Review Response

Project Name: Cui Pier Extension

Response To: Planning Comments

This letter is in response to the corrections SHL23-030 & SEP23-012. Below are our responses to the questions/comments from 09/26/2023.

PROPOSED CONDITIONS

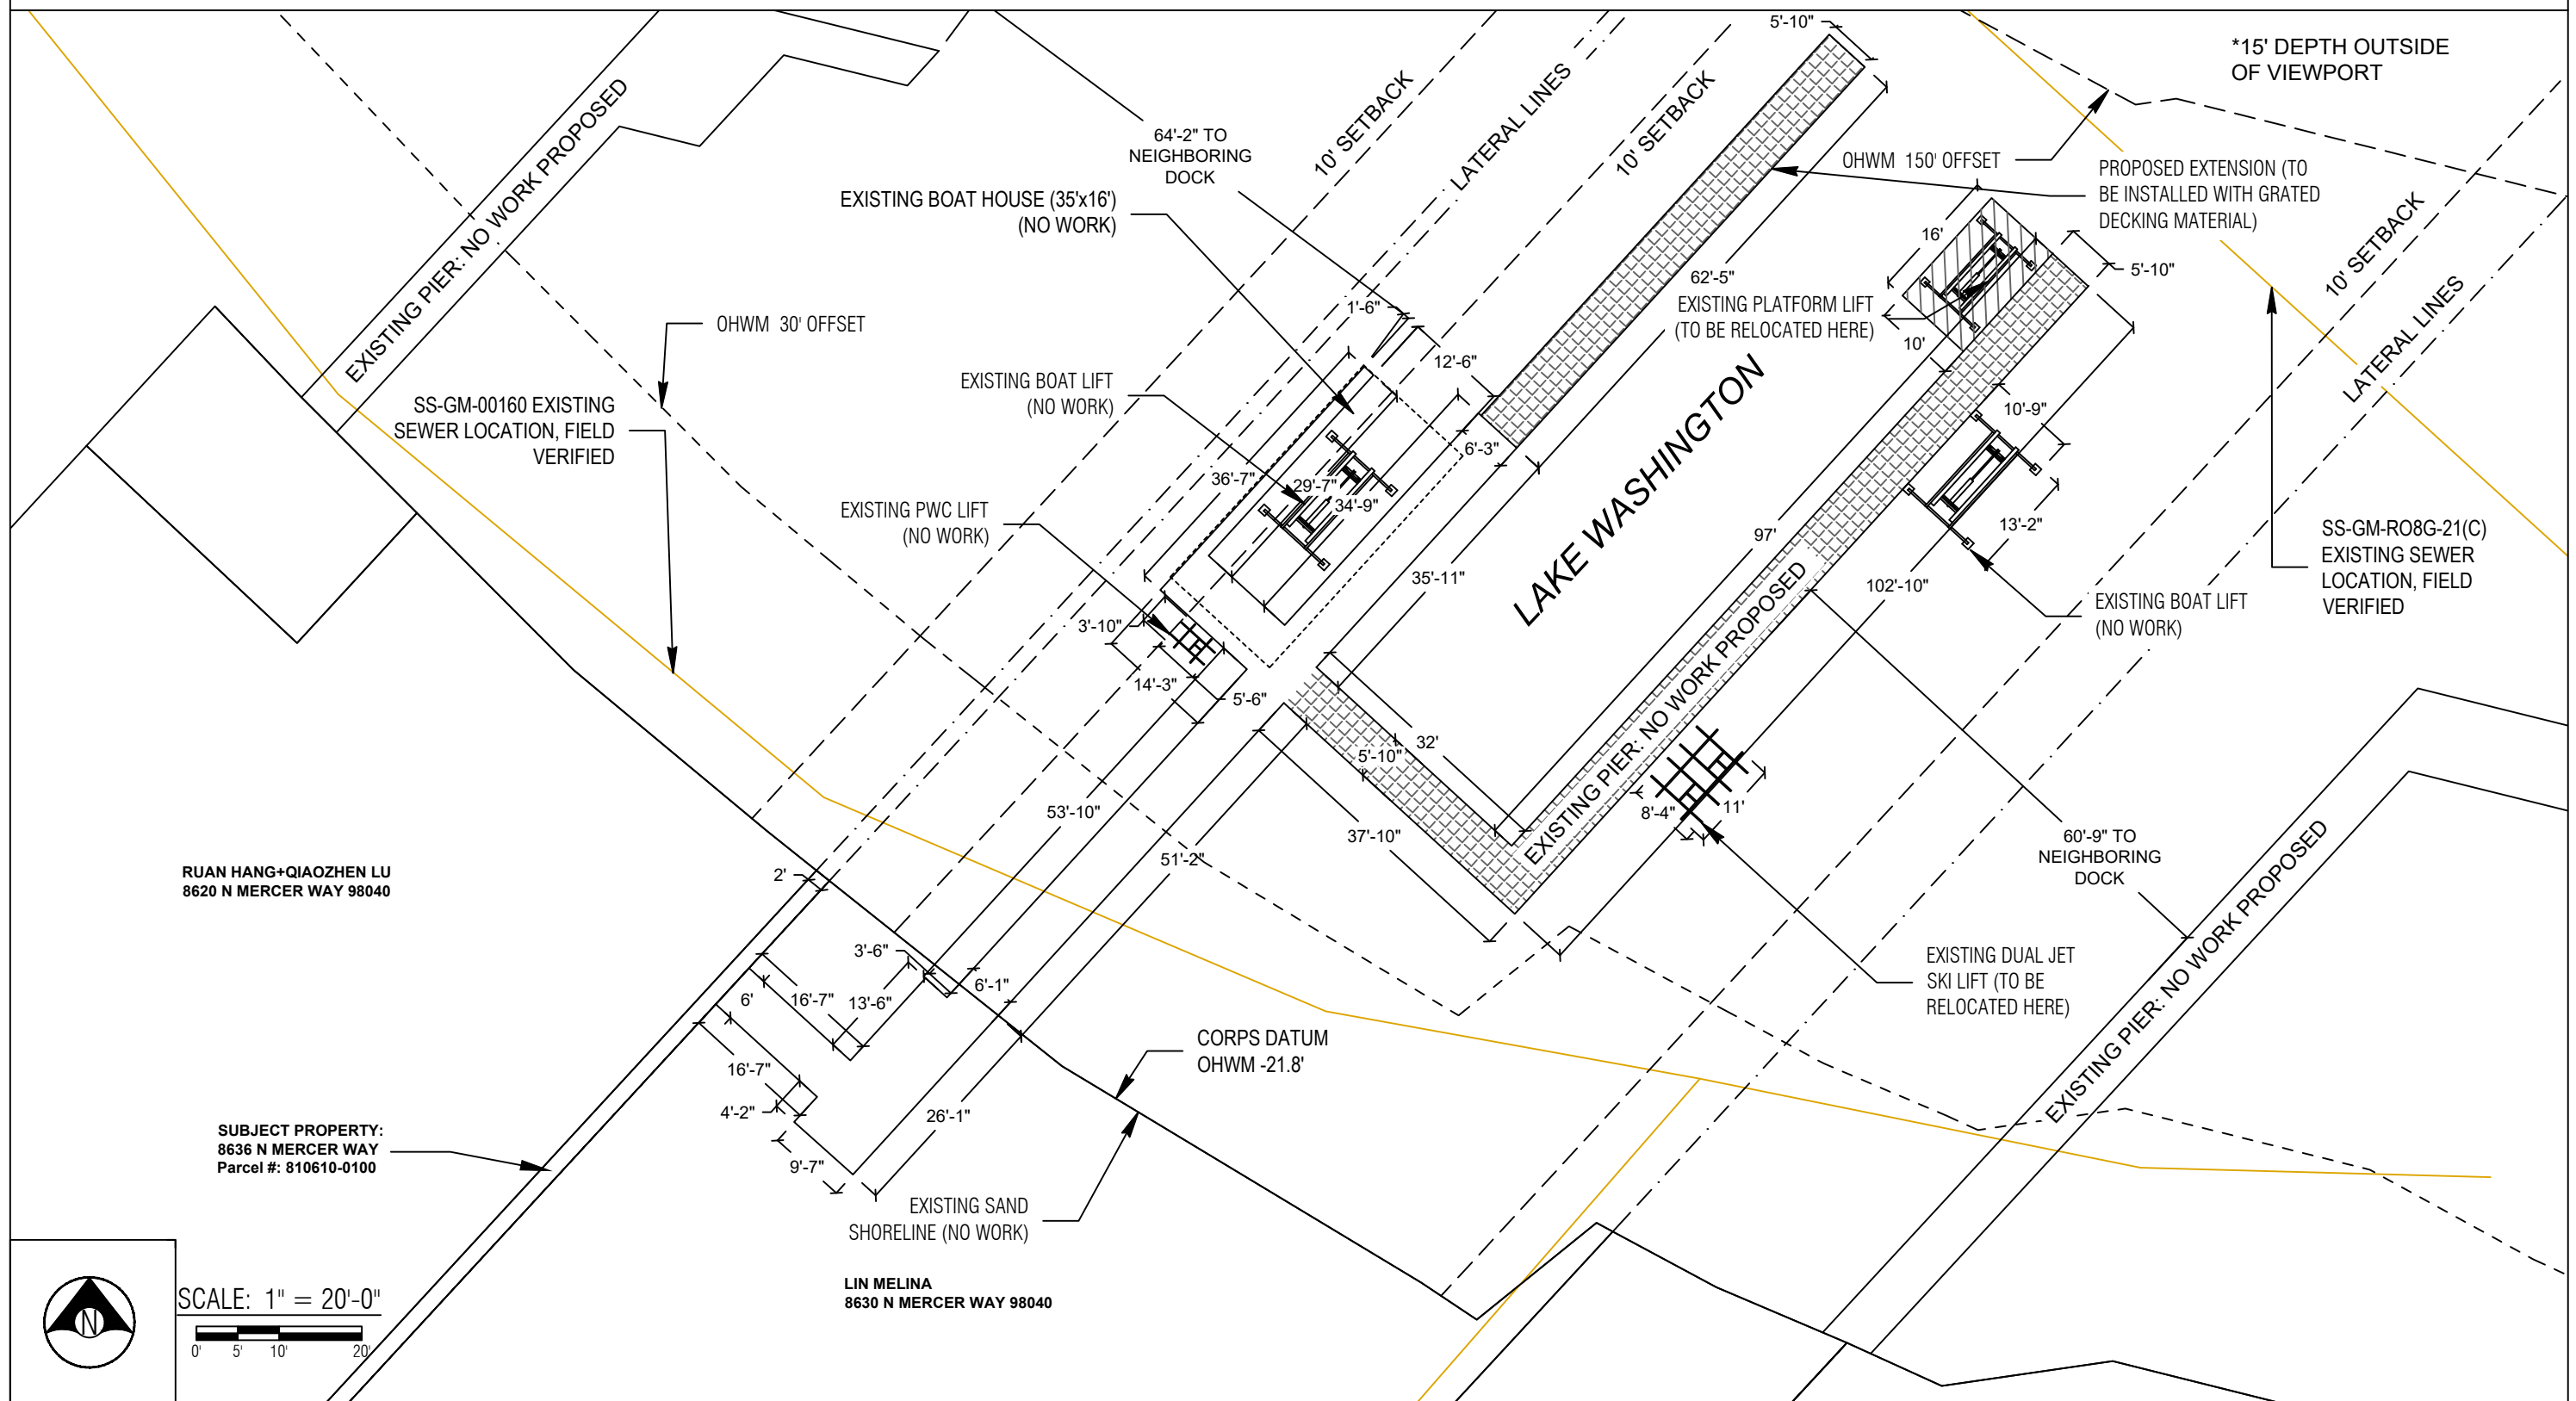
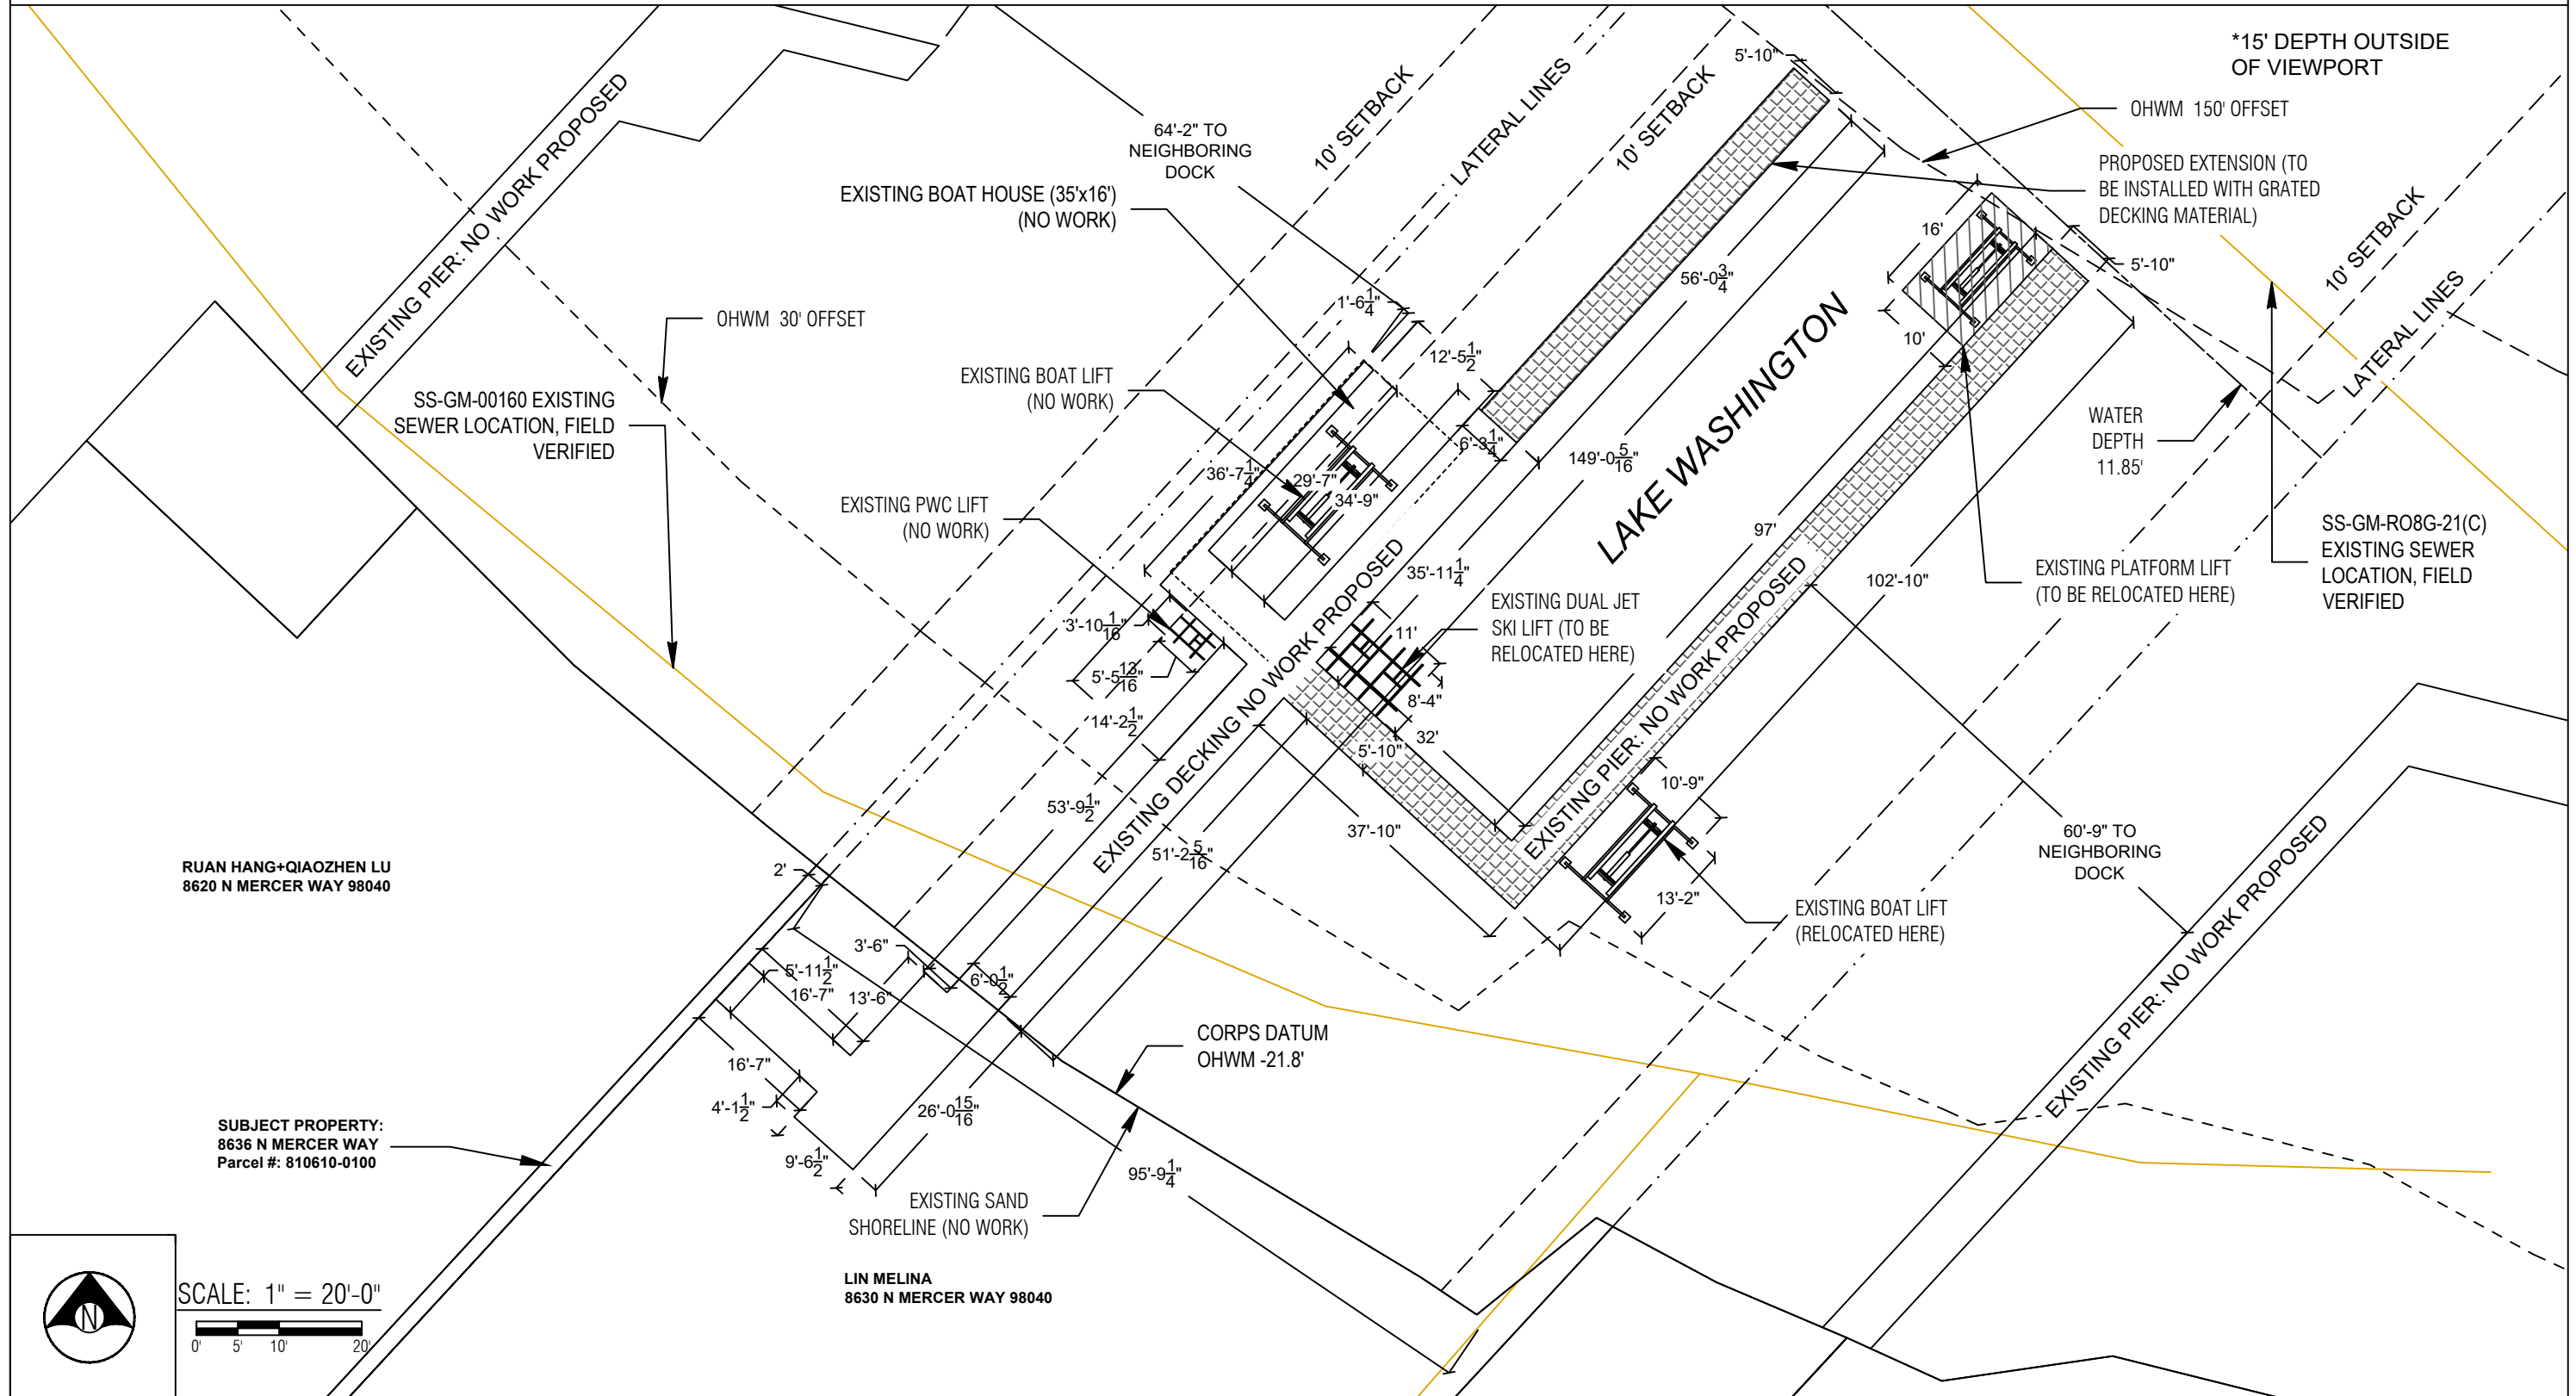
5. Easement Agreement
 - a. See agreement to construct dock.
 6. Navigation for neighbors to the north
 - a. The proposed extension will be maintained at over 75' distance from the North Pier's slips, this distance exceeds what is required for safe maneuverability of any vessel that would be safely moored in the North pier's slips.
